218984

Appendix A

Record and Response to Submissions

Extracts from Government agency and authority submissions received in relation to SSD 18_9270, and a response to each of these matters, has been outlined in the table below. It is noted that no submissions were received from the general public.

Overlay of shadows cast by approved North Site Stage 1 SSD DA building envelope and proposed Stage 2 SSD DA North Tower (comparison provided as defined by Condition B2(b) of Concept Approval SSD\_8351)

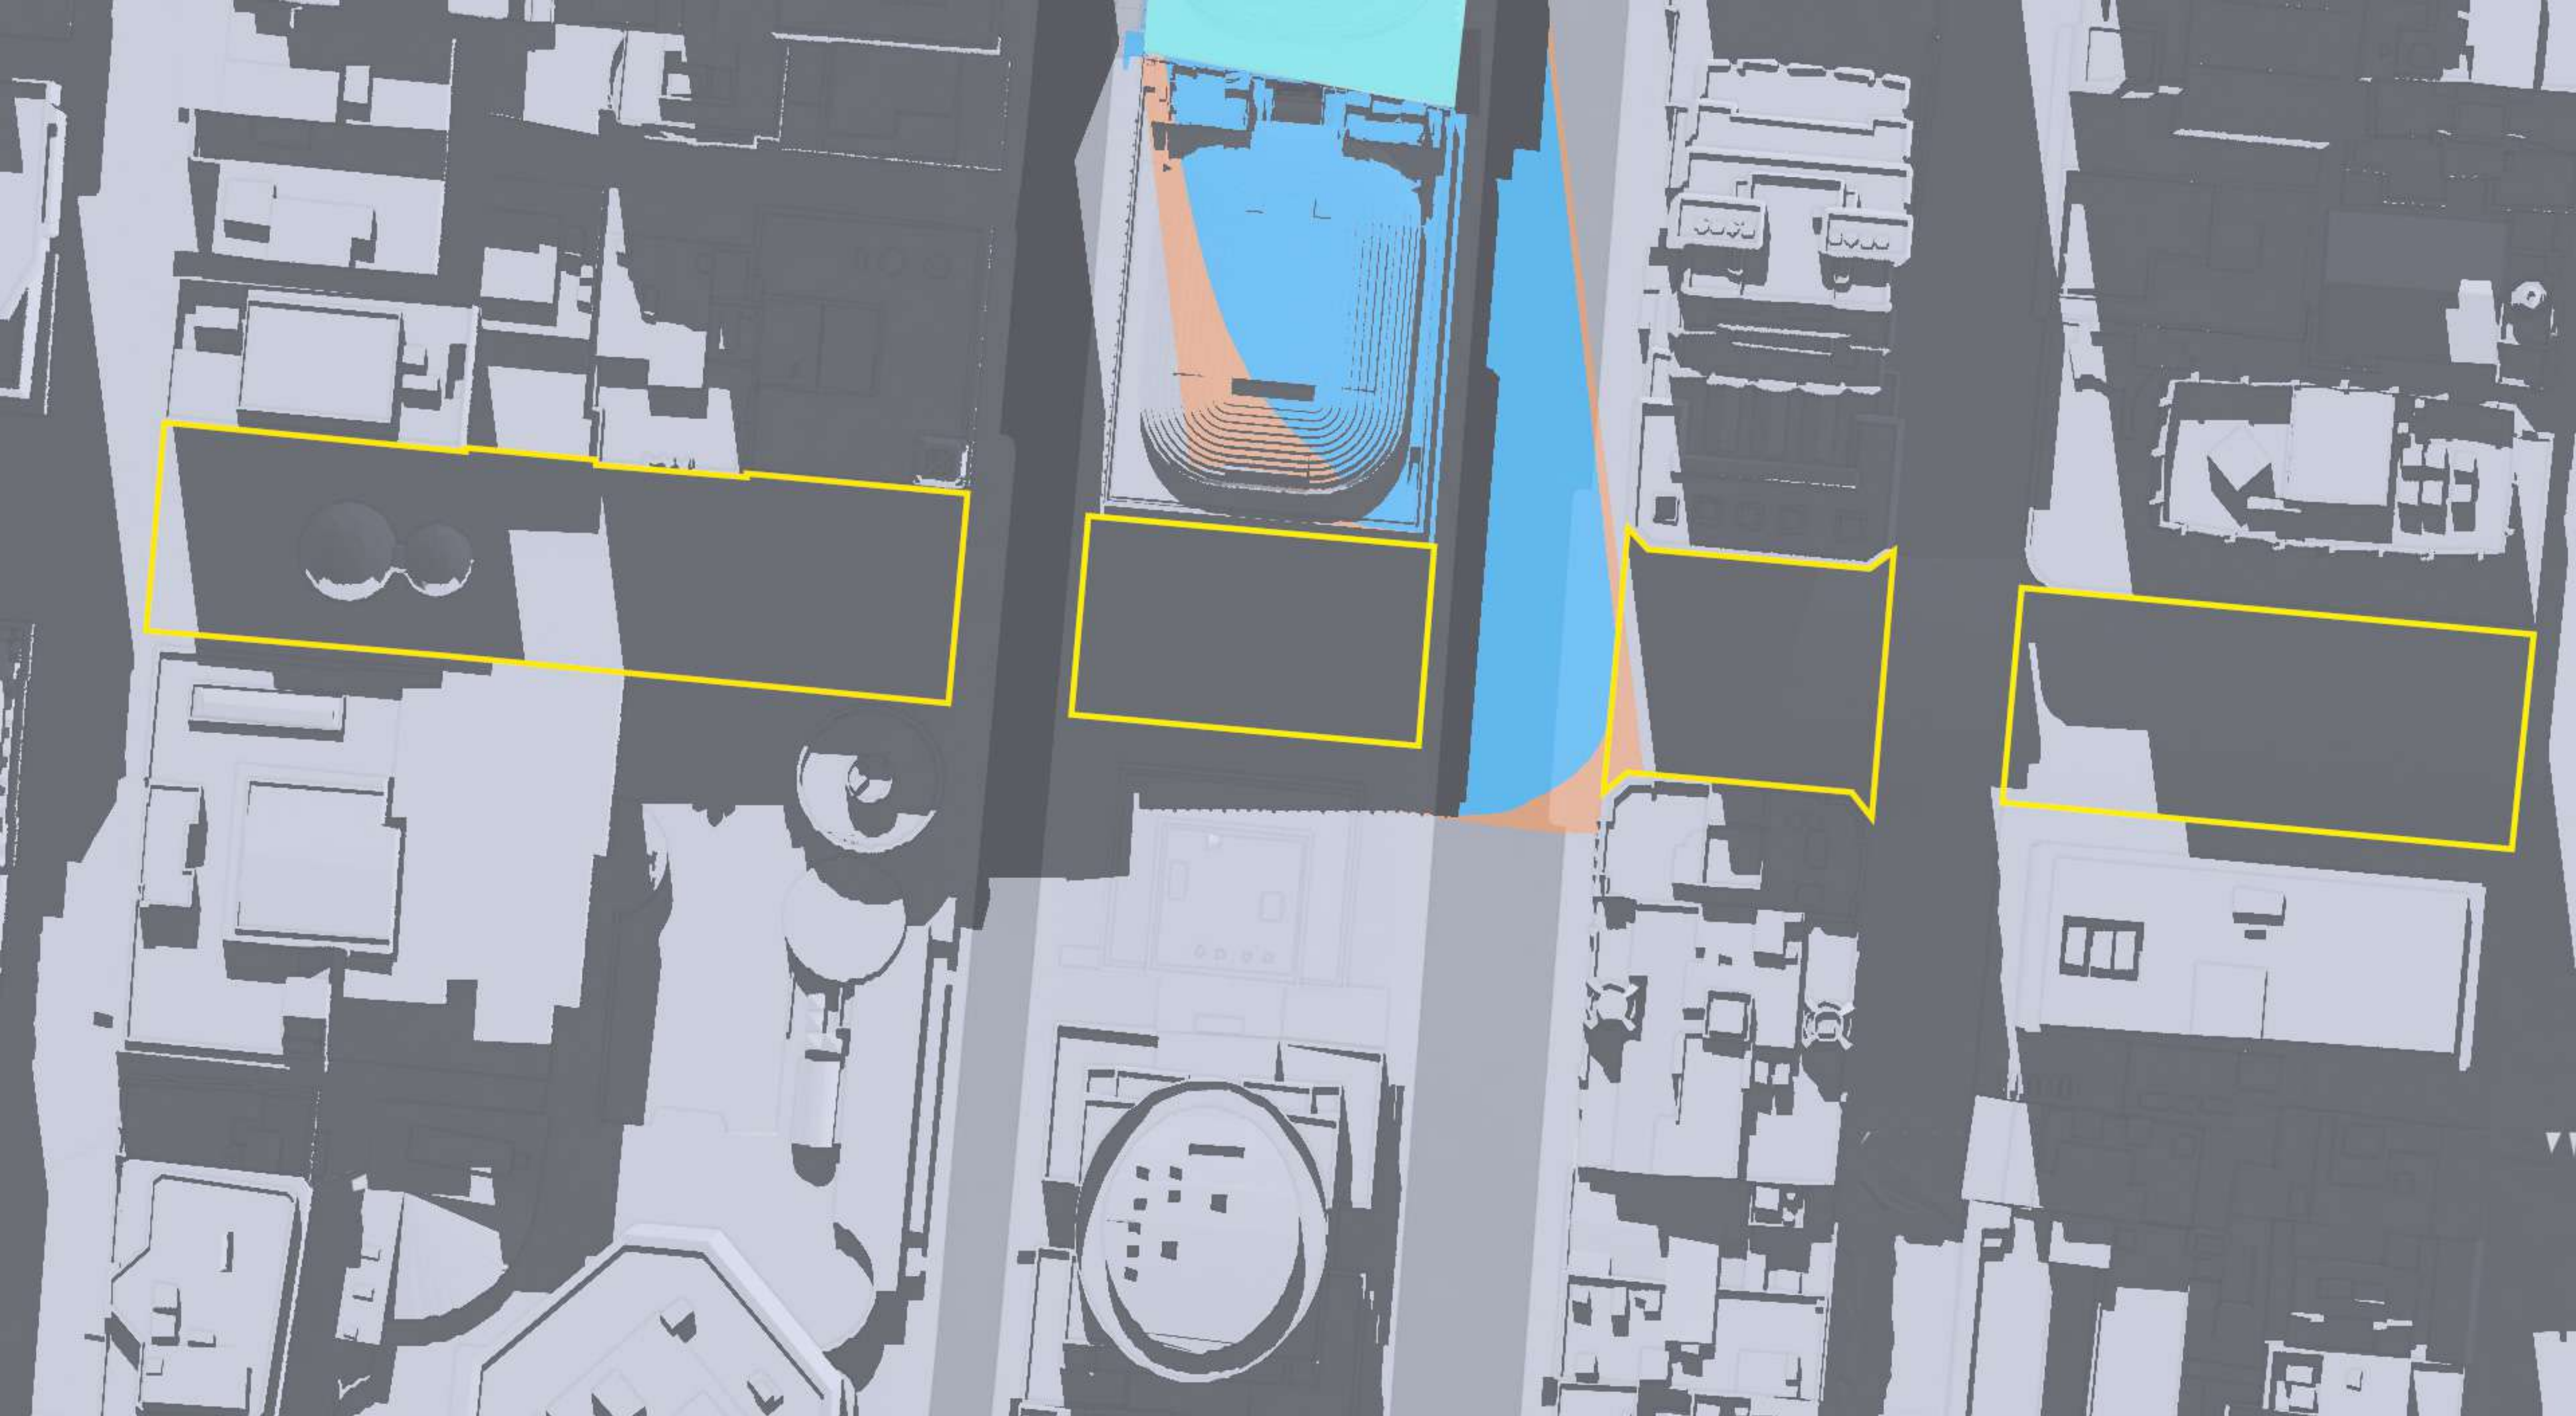
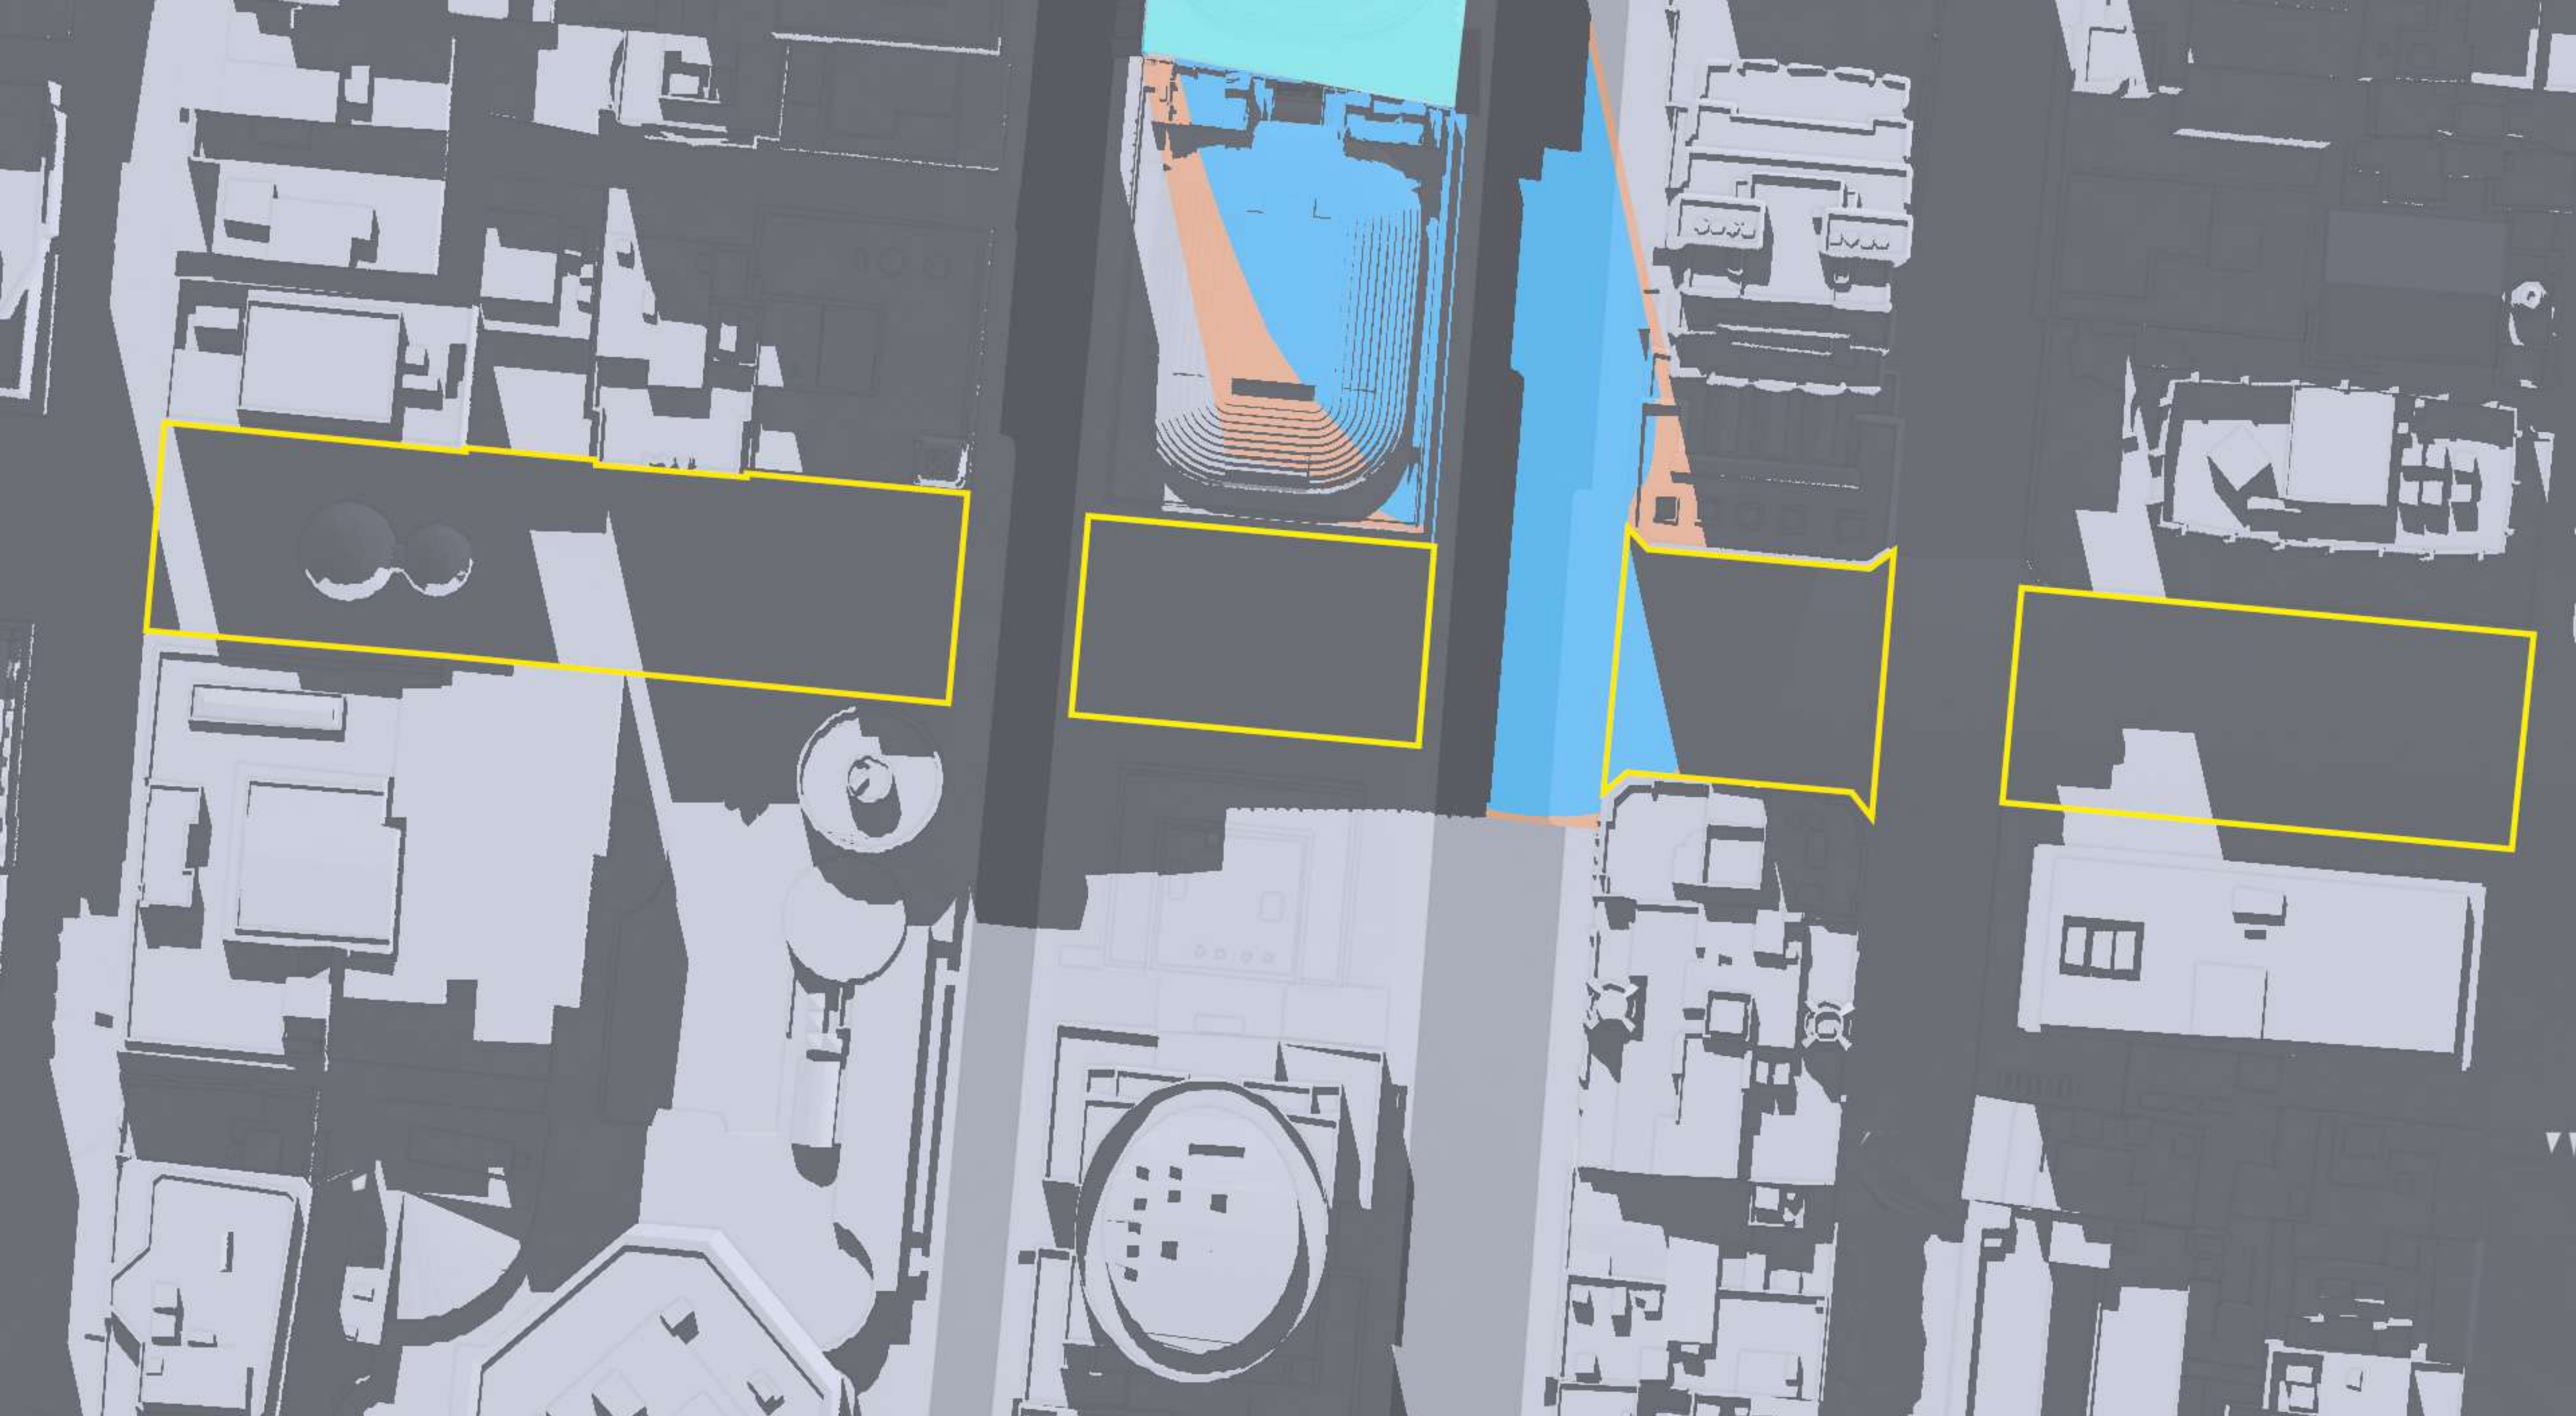
Extract	Response
<p><i>In particular a setback above the podium is essential for Elizabeth Street frontage to address overshadowing of Martin Place which is avoidable.</i></p>	<p>The detailed built form of the North Tower has been the subject of ongoing assessment and development, which has demonstrated that the imposition of tower setbacks will not significantly improve the amenity of public areas surrounding the site. As is discussed in detail in Section 2.1.3 of the RTS, the provision of setbacks above the podium will not significantly improve environmental impacts to the amenity of the surrounding streets in terms of wind, skyview, and overshadowing.</p> <p>When considering the overshadowing impact of the proposal, the overall shadows cast by the proposed detailed design provide 299m² of additional solar access to the ground plane of Martin Place when compared to shadows cast by the approved building envelope. The additional solar access to Martin Place equates to 18% more additional direct sunlight between 12pm and 2pm on 14 April when compared to the approved building envelope and therefore meets the requirements of Condition B2(b).</p>
